Consultation Response from KC, Conservation & Design**2022/91968 Jamia Masjid Osman, 32, Upper George Street, Springwood, Huddersfield, HD1 4AW****Partial demolition, rebuild and extensions and alterations to mosque (Within a Conservation Area)****Date Responded: 17.3.2023****Responding Officer: Sue Brooks****Responding Ref:**

Proposed South Elevation

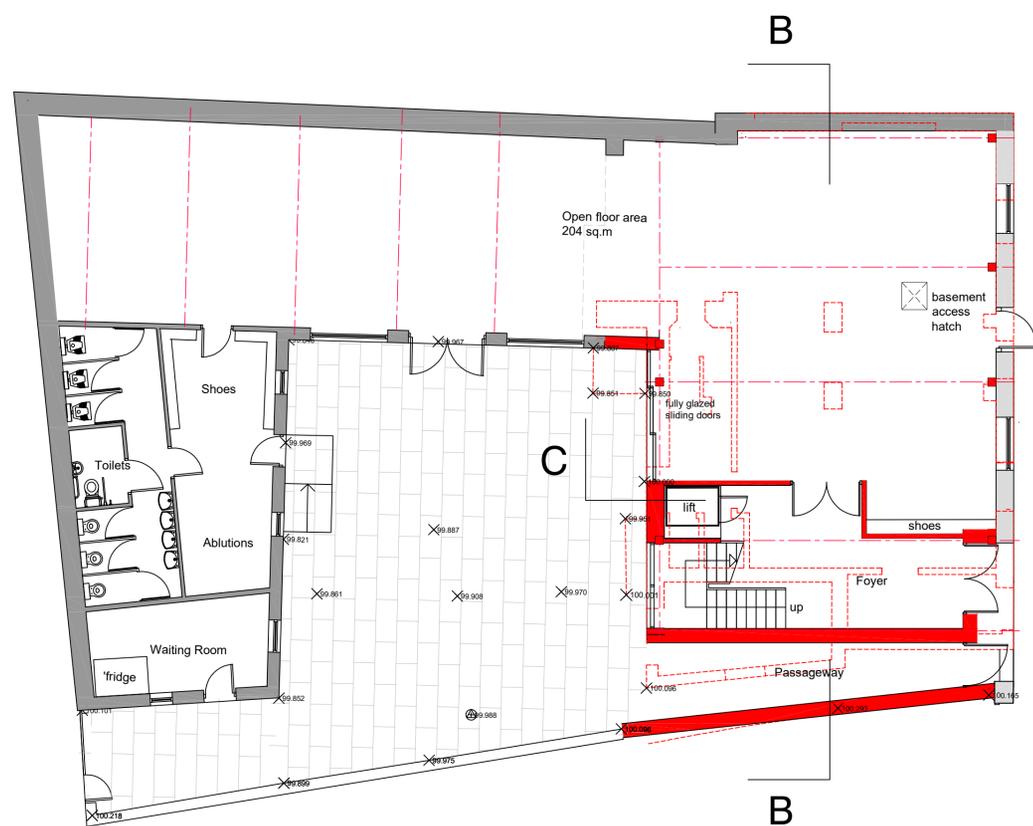
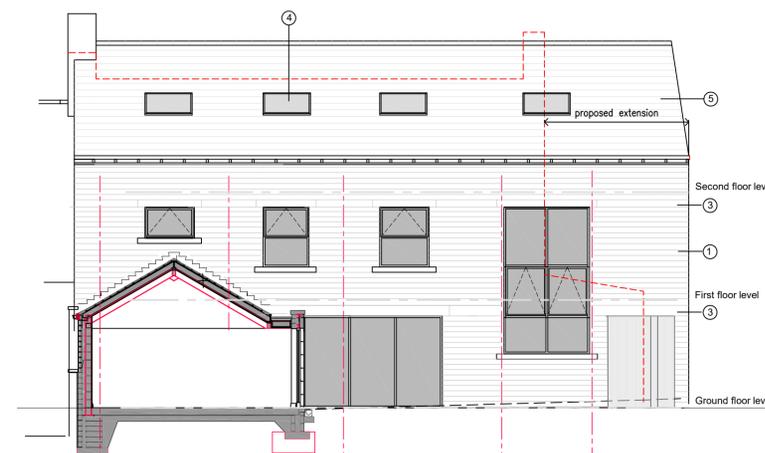
The proposal is to demolish the entire original building and construct a taller building with a similar façade built in ashlar stone, the complete reconfiguration of the rear elevation, and a two-storey extension at the northern end. Internally, the ground and first floors will be open plan.

The Conservation and Design Team is unable to support the proposal in its current form. The full demolition of a historic building within this conservation area will lead to a high level of less than substantial harm, and therefore clear and convincing justification needs to be provided with sufficient public benefits to outweigh the harm.

We would recommend that the applicant investigates reconfiguring the existing building in its current form, with discreet repairs to the facade where movement has occurred (is it only historic movement or still ongoing?), and necessary repairs to the building. This will maintain the significance of a building which makes a positive contribution to the character of the conservation area and street scene.

If the building is beyond economic repair, this needs to be clearly demonstrated by the submission of a structural report and evidence to justify complete demolition and rebuilding. If it can be justified, we will re-assess the application and provide comments on the proposed scale and design.
